DRB CASE NO/PROJECT NO: 1003188

DRB Application No.: 08DRB-70349 Project # 1003188
Project Name: LOT 26 R. LUKE ADDITION
Agent: COMMUNITY SCIENCES Phone No.:

RE: Lot 26R, Luke Addition, and Tracts 144B-1, 145A-2, & a
portion of Tract 145A, MRGCD Map #31

RE: Lot 26, Luke Addition / Delrose Place

SHEET 2 OF 2

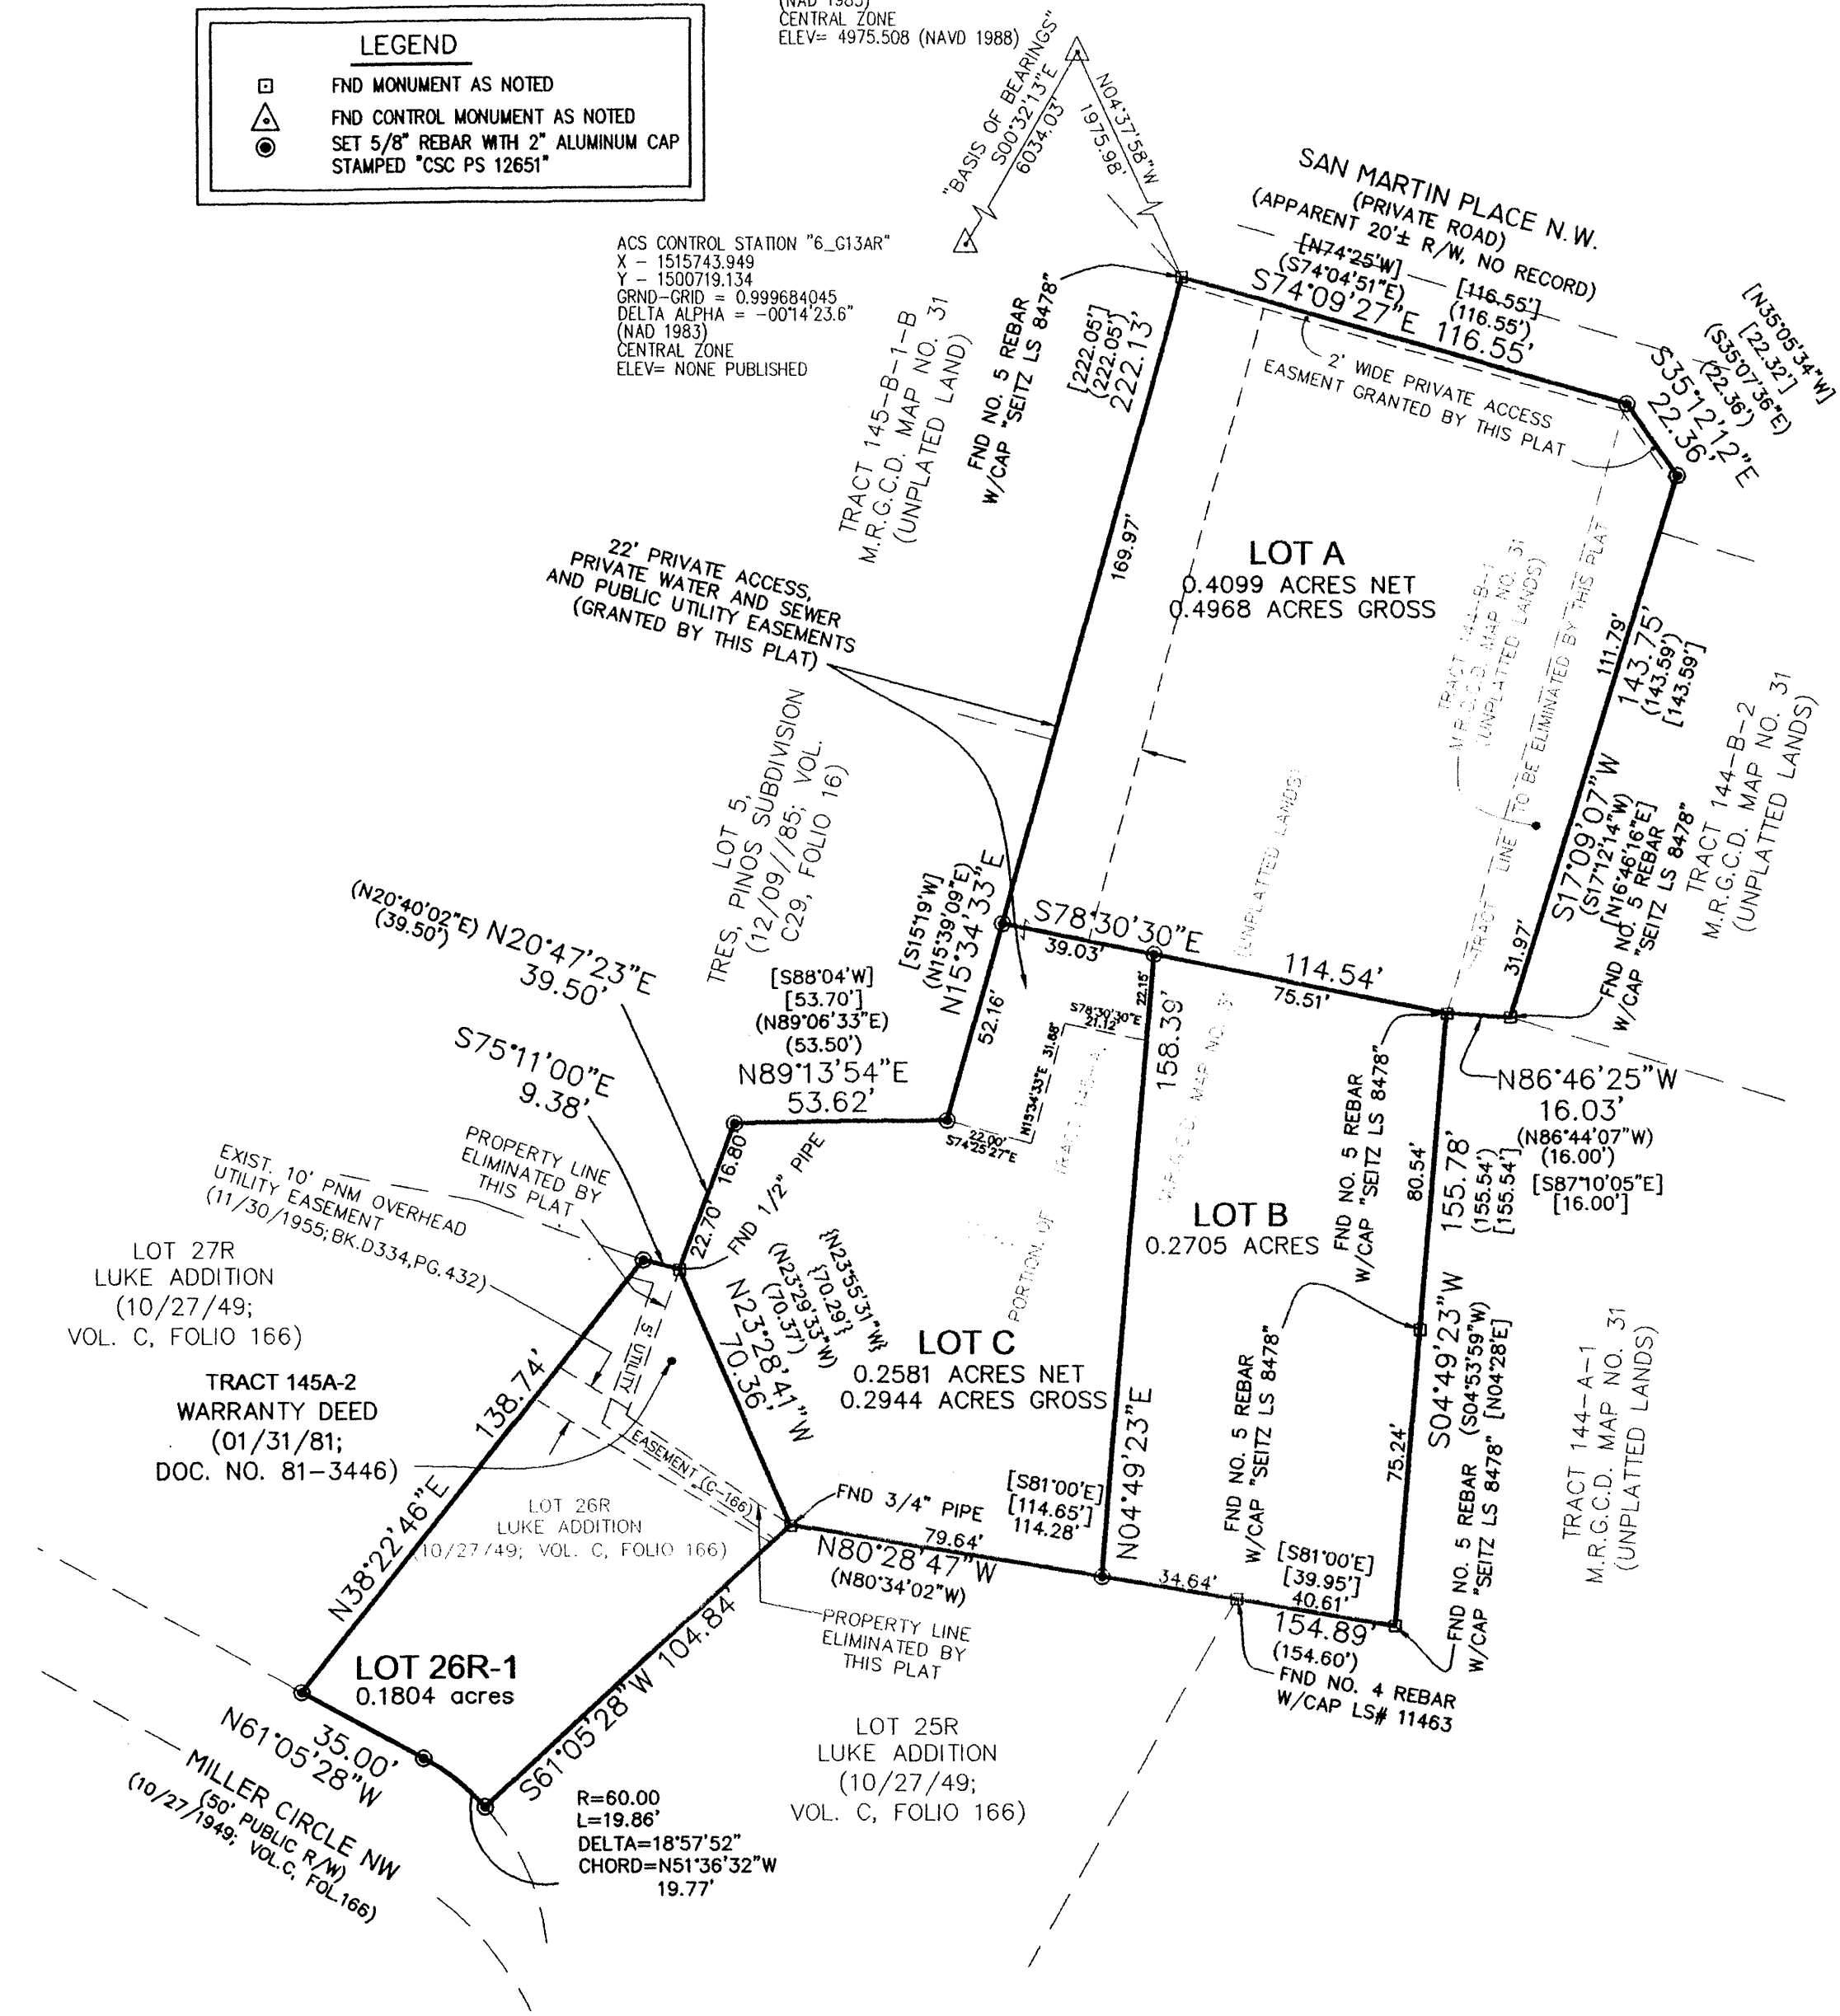
Note/ describe easement area on proposed lot C.

SKETCH PLAT OF TRACTS "A", "B" & "C", DELROSE PLACE AND LOT 26R-I, LUKE ADDITION

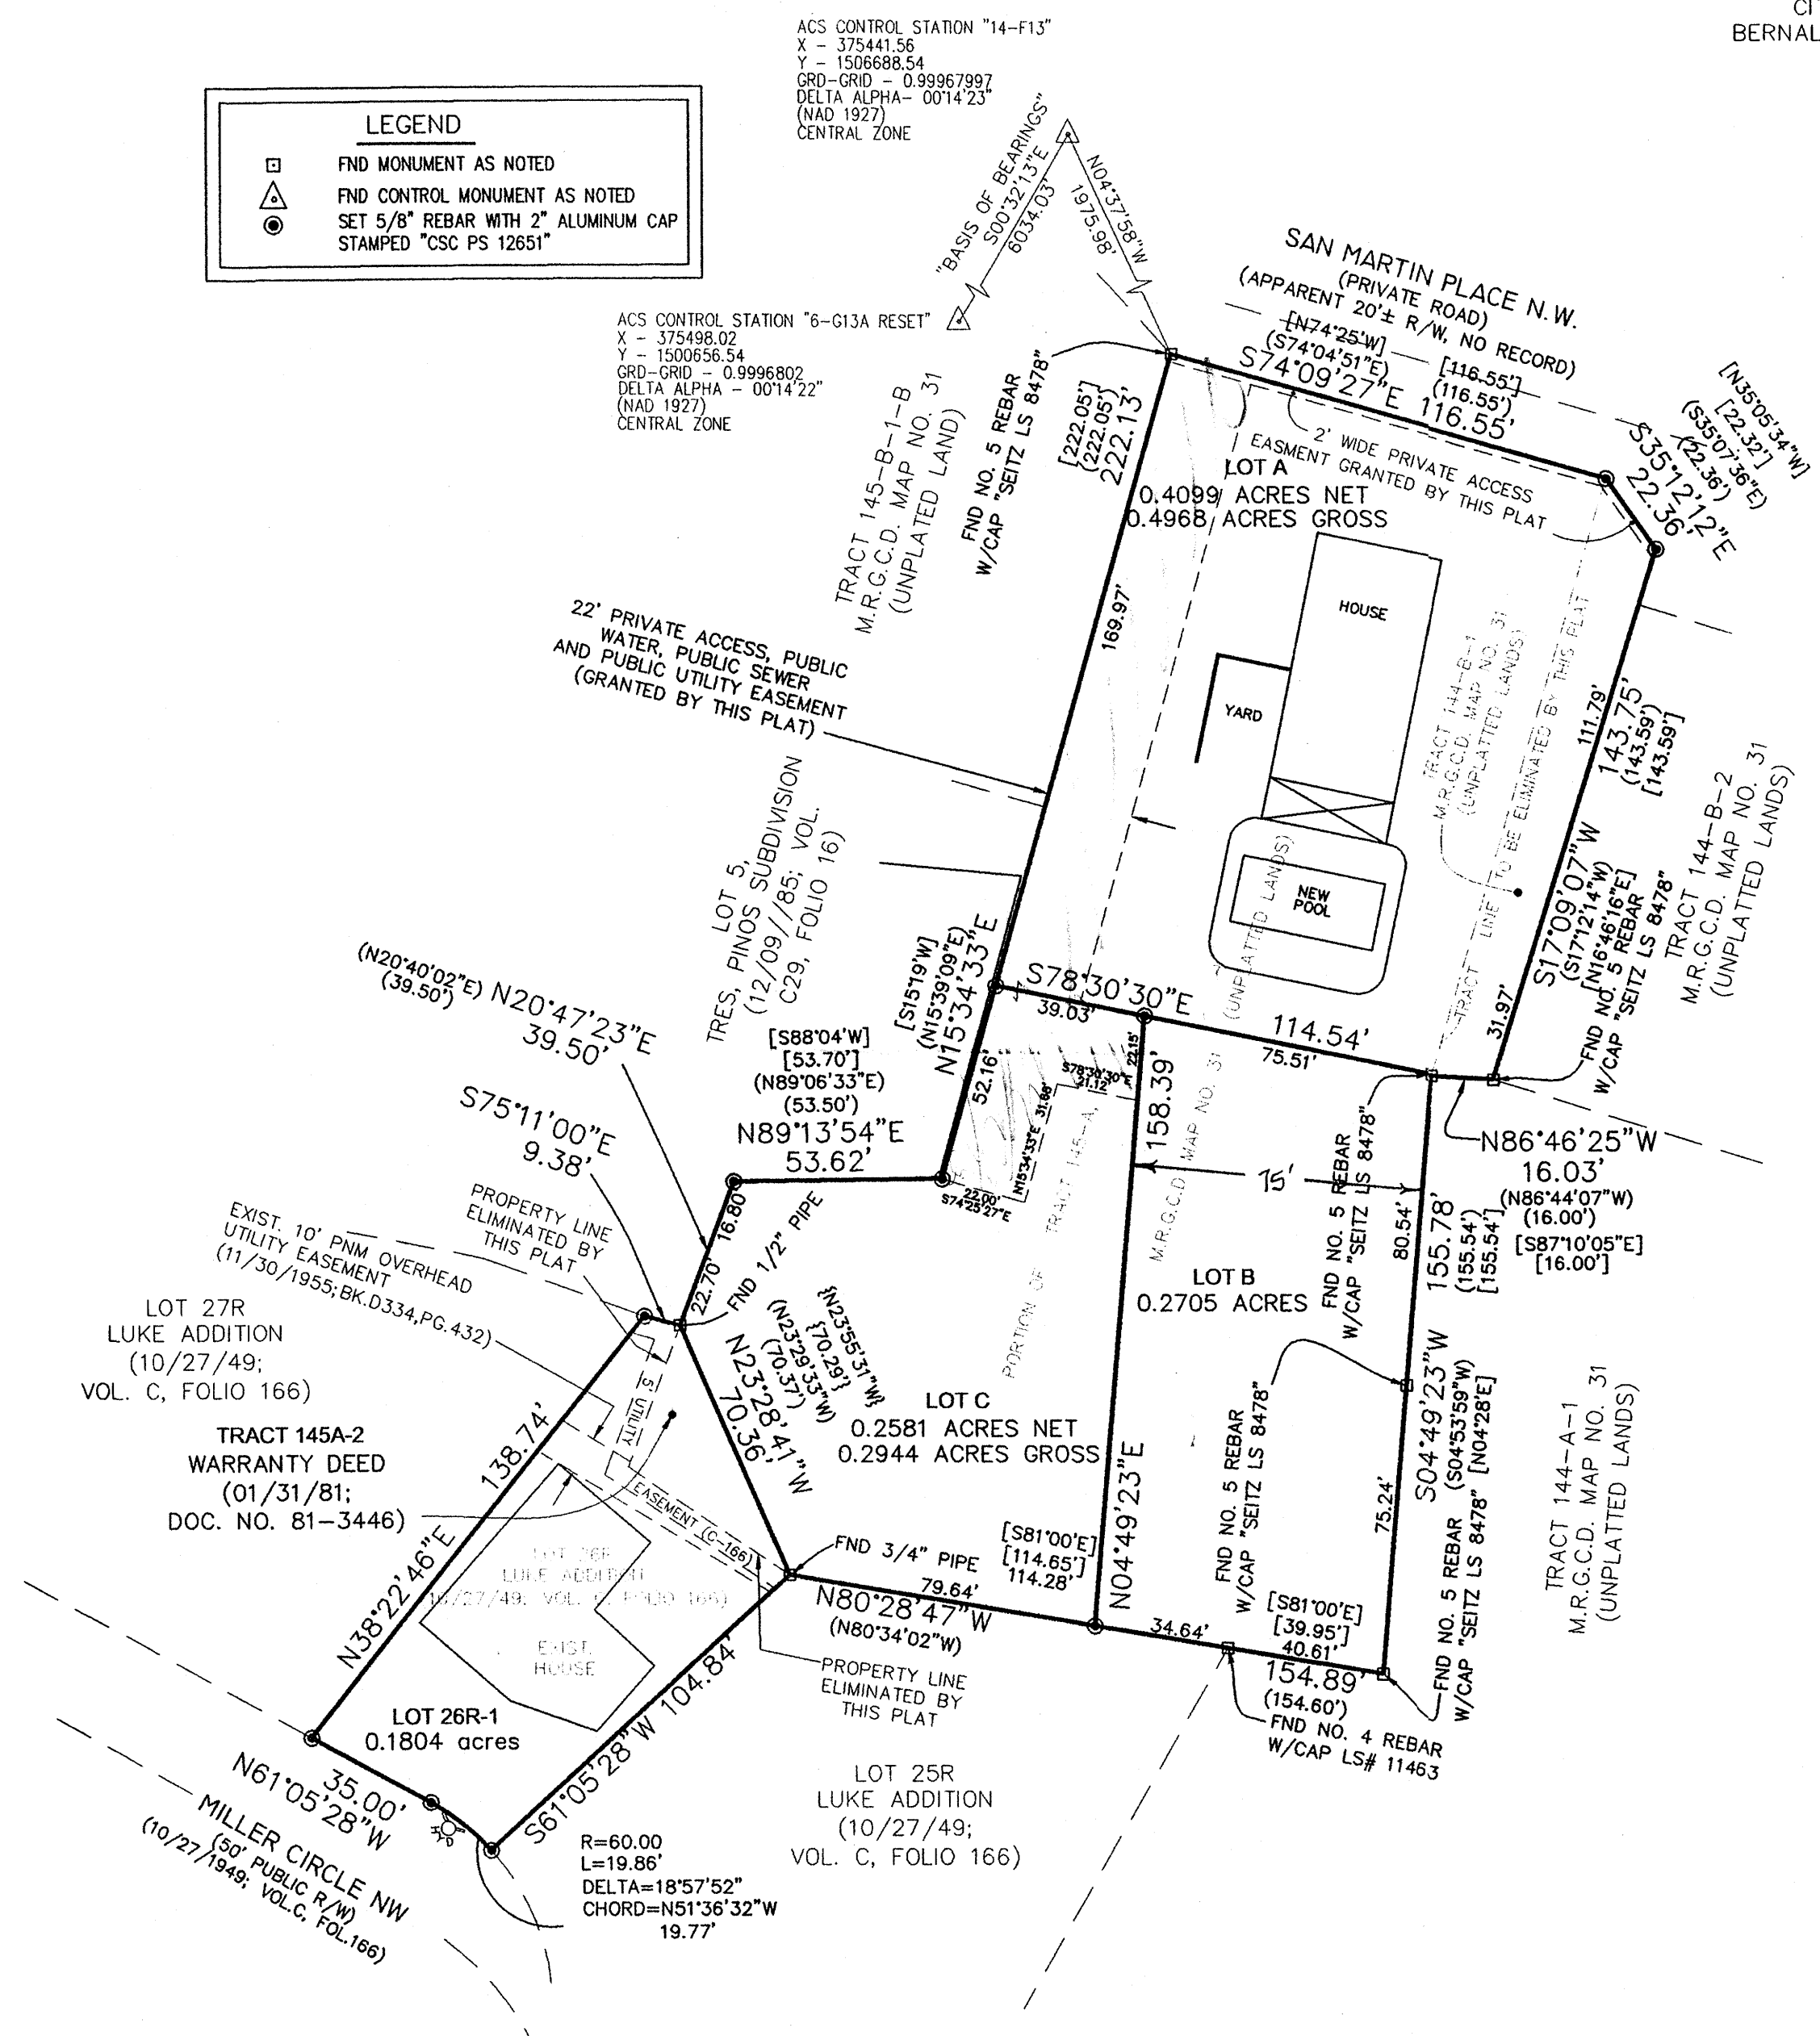
Please indicate NET lot area (exclusive of access easement) for the front two lots (A and B).

Blank signature block will be needed for re-approval; solar access note will be needed.
